AUSTRALIAN TECHNOLOGY PARK, EVELEIGH

SSD 7317 MOD 2

Environmental Assessment Report
Section 96(1A) of the *Environmental Planning
and Assessment Act 1979*

General Arrangement Plans 1:250
 Lower Ground

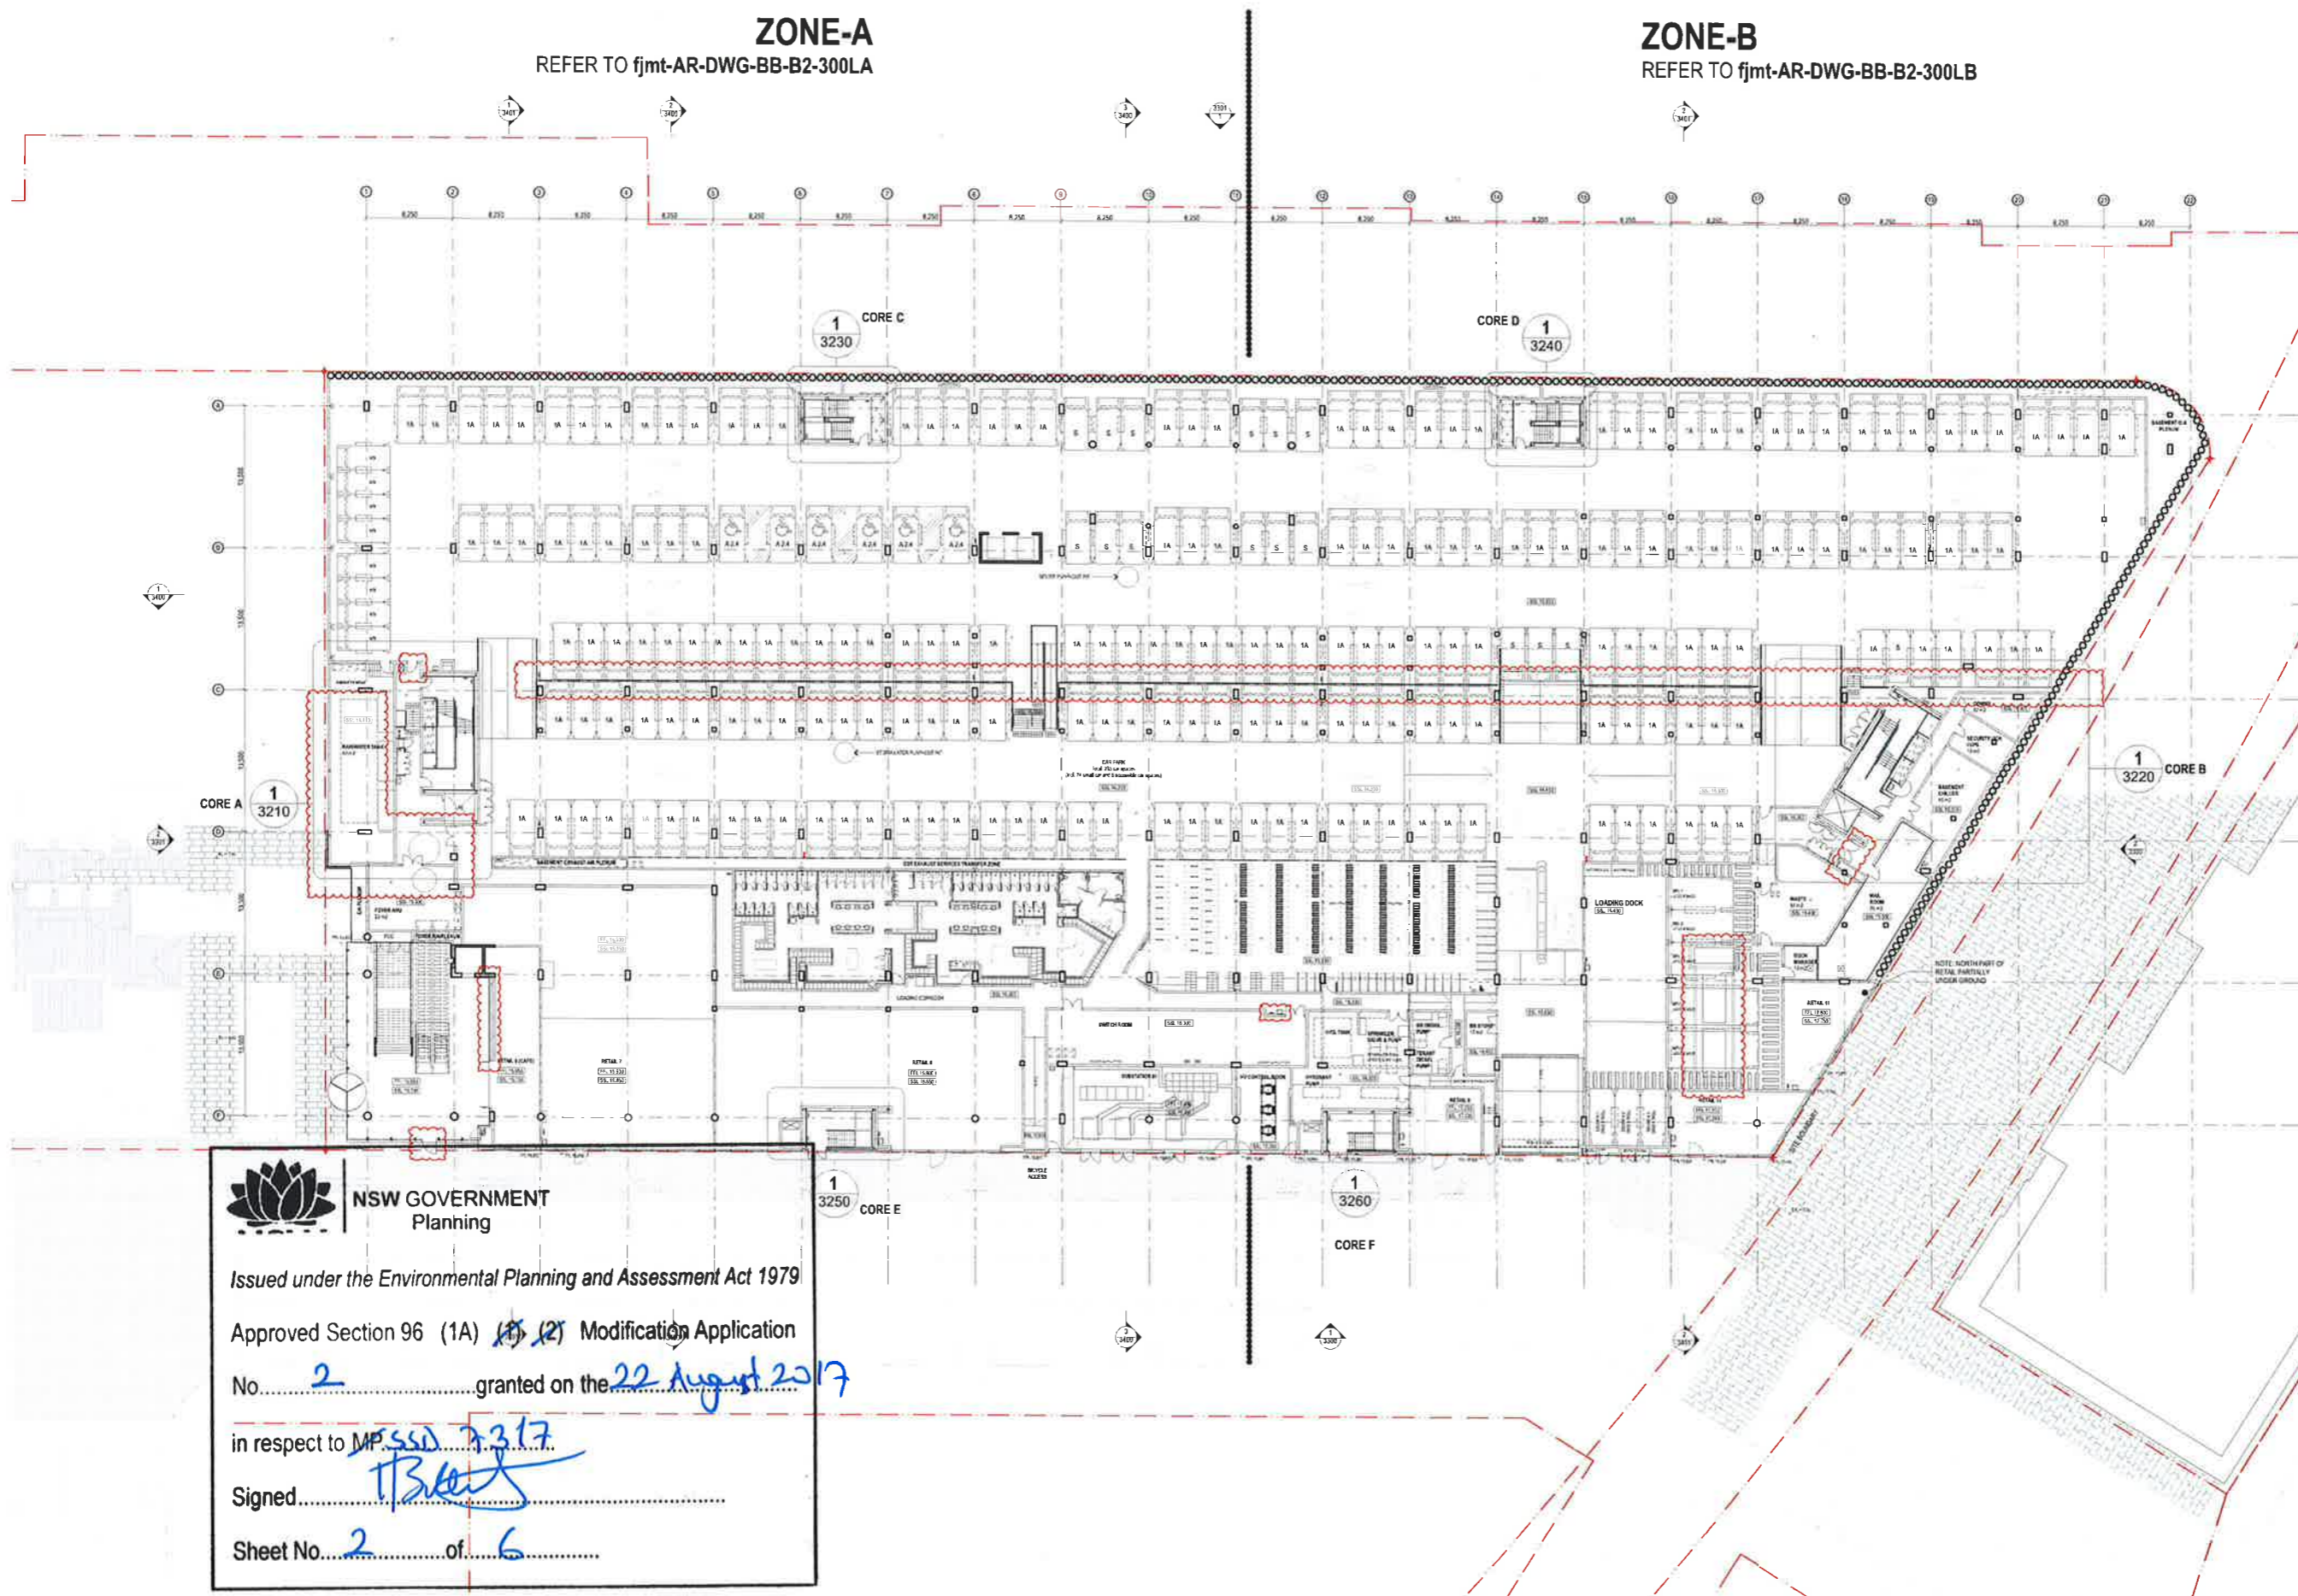
- the modification moves the loading dock entrance sufficiently away from the pedestrian intersection of Central Ave and Mitchell Way and consolidates it with the vehicle entrance, therefore improving pedestrian safety at its junction

- the reconfigured internal layout appears orderly and reasonable with good direct access provided to the internal bike storage and end of trip facilities.

The Department therefore supports this component of the proposal. The Department also notes that modification to the loading dock addresses the requirements of Condition B3(b)(3), by relocating and consolidating the loading dock entrance with the vehicle entrance in Building 2. As this condition has now been addressed, the Department recommends deletion of Condition B3(b)(3).

**Australian Technology Park
Indicative Parking Plan**

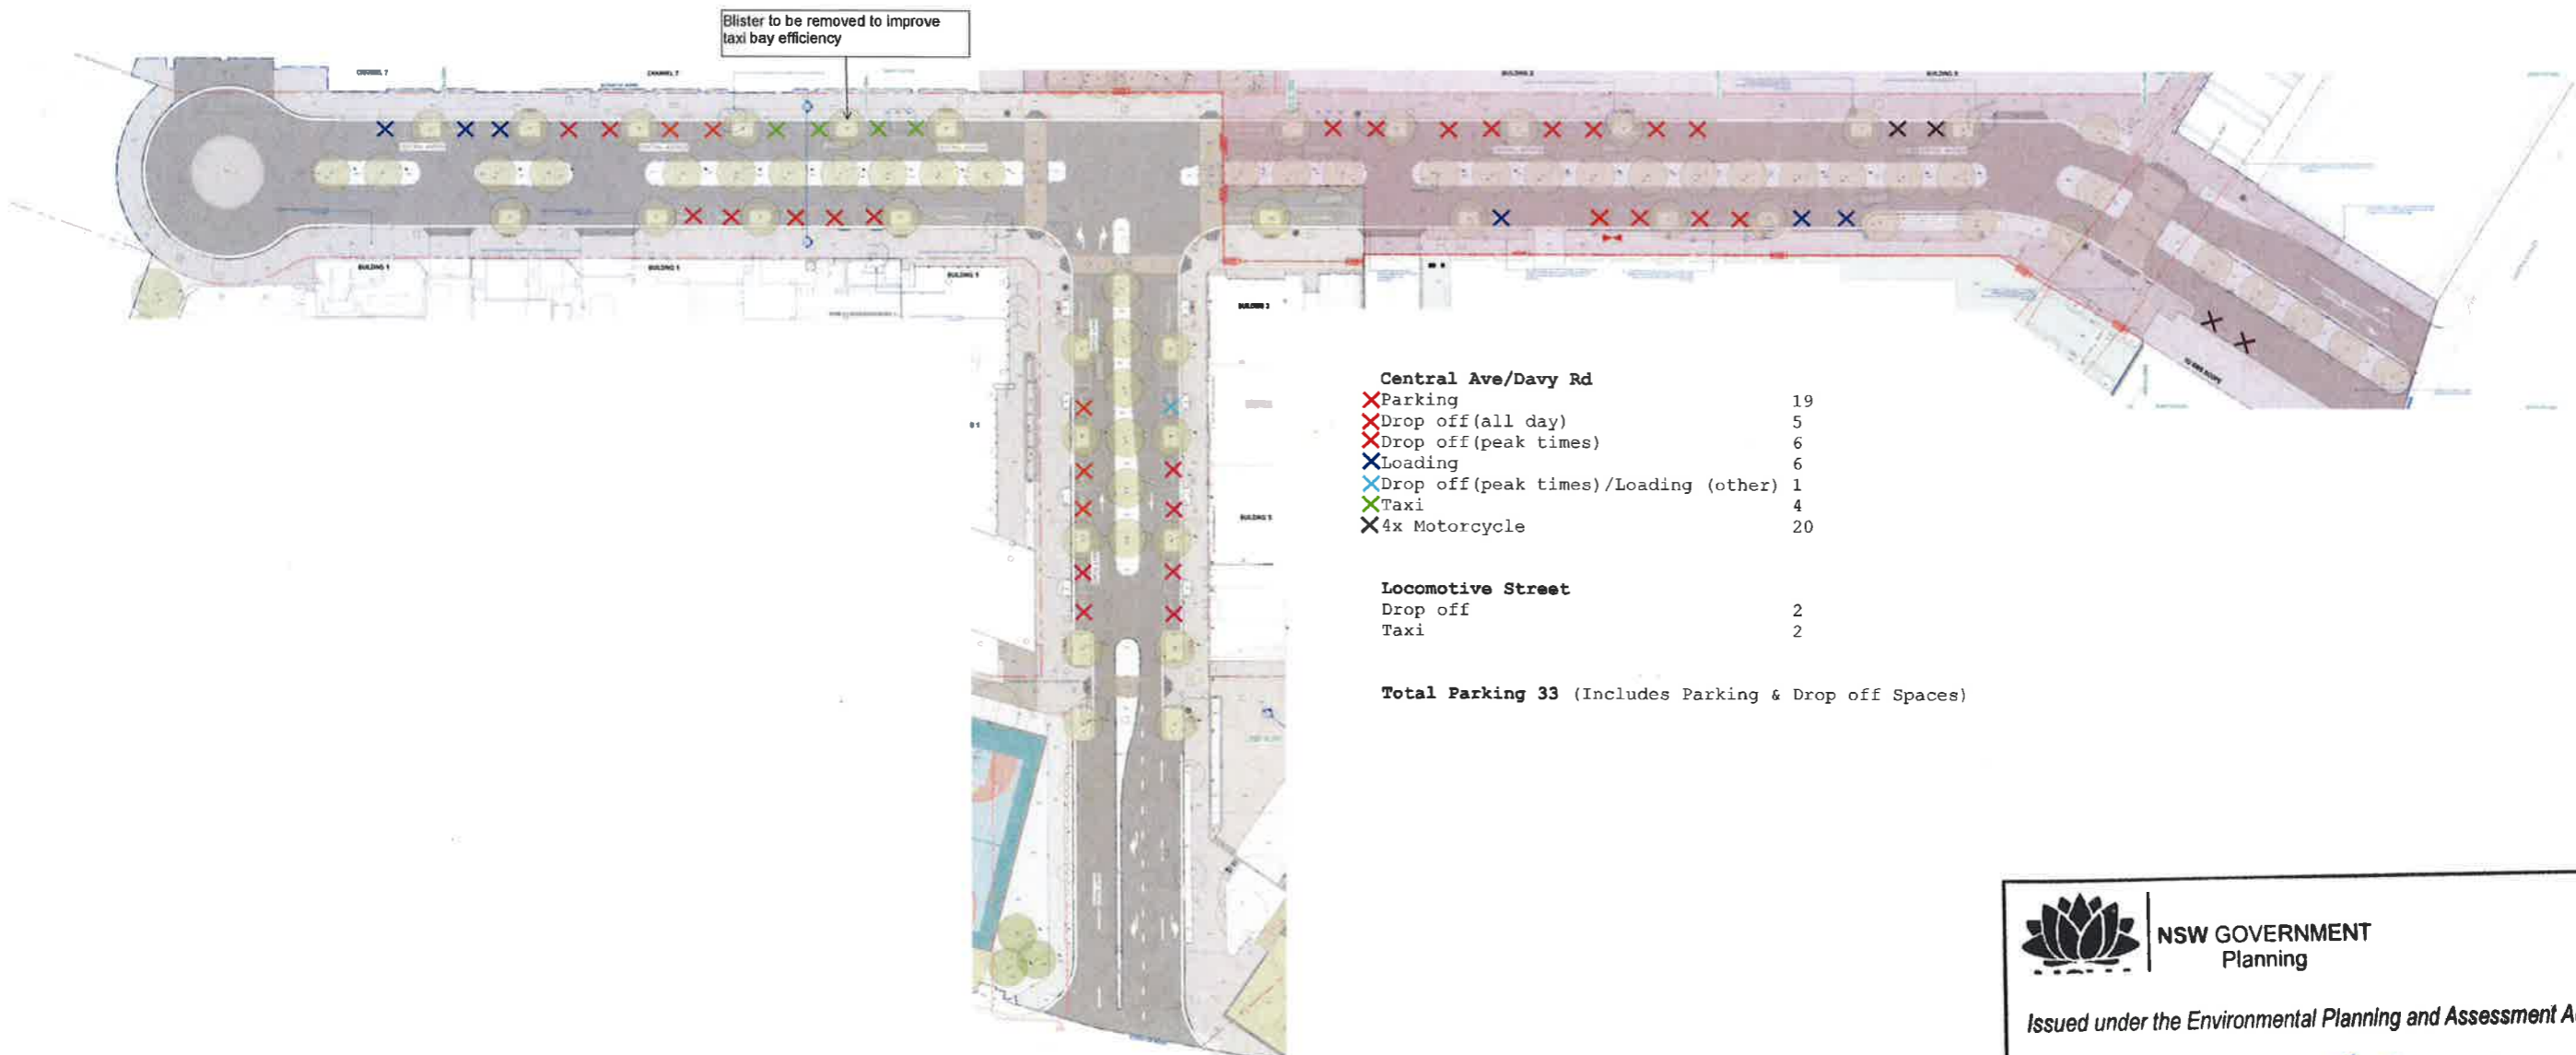
In relation to the reduction of car parking within the public domain, the Department notes the 42 spaces approved within the public domain is a maximum provision. The detailed design of the public domain has progressed in consultation with Council and through this process the detailed location of all public domain infrastructure and car parking is more resolved. The public domain plans will be ultimately be submitted for approval by the Secretary in accordance with Condition B53.

Council, as the future custodian of the public domain, did not raise any concerns about the reduction of on-street parking. The Department also accepts the reduction in car parking within the public domain as a positive design outcome.

title  
**Elevations 1:250**  
**Elevations - South & East**

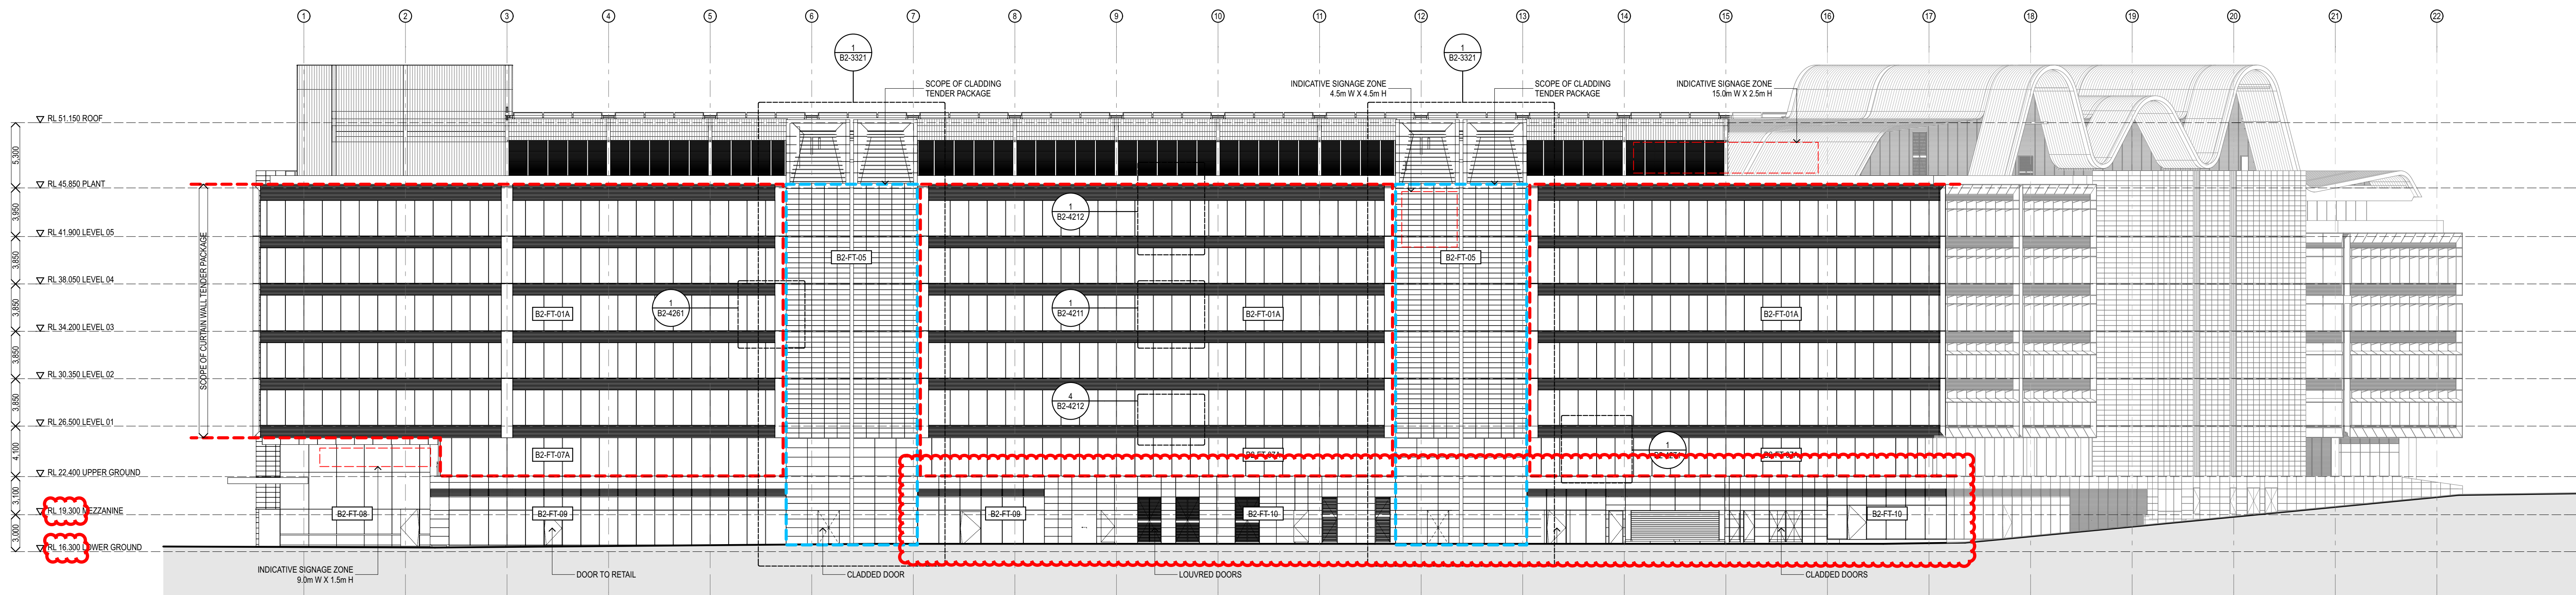
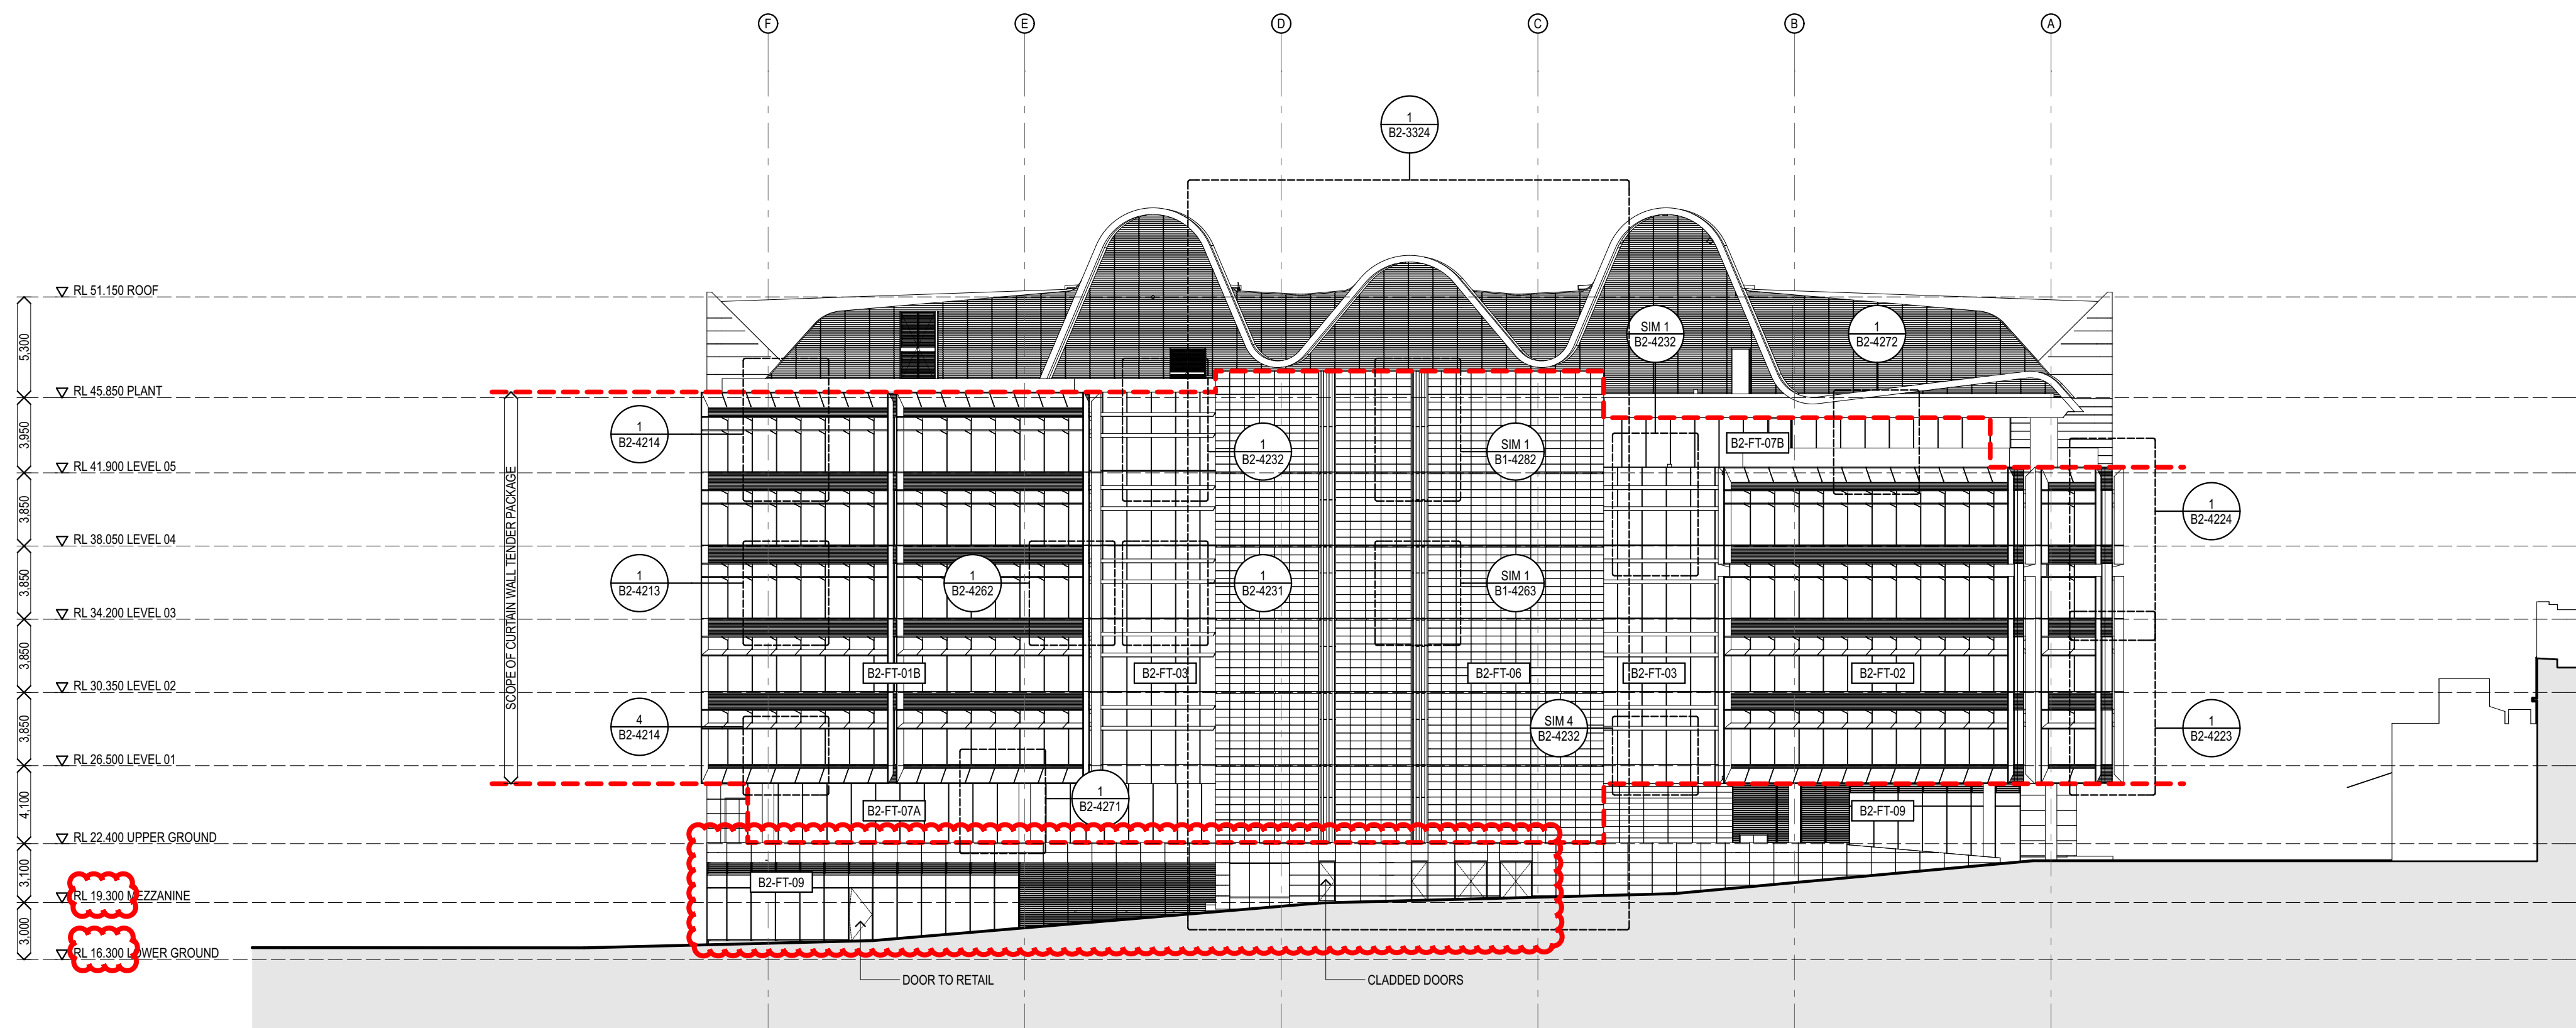
- while modifications to the Lower Ground Level will alter the appearance of the southern and eastern elevations to a minor extent, appearance of the building façade will be enhanced by the placement of additional retail tenancies, and the amendments do not alter the appearance of Building 2 and its interface with the Locomotive Workshop
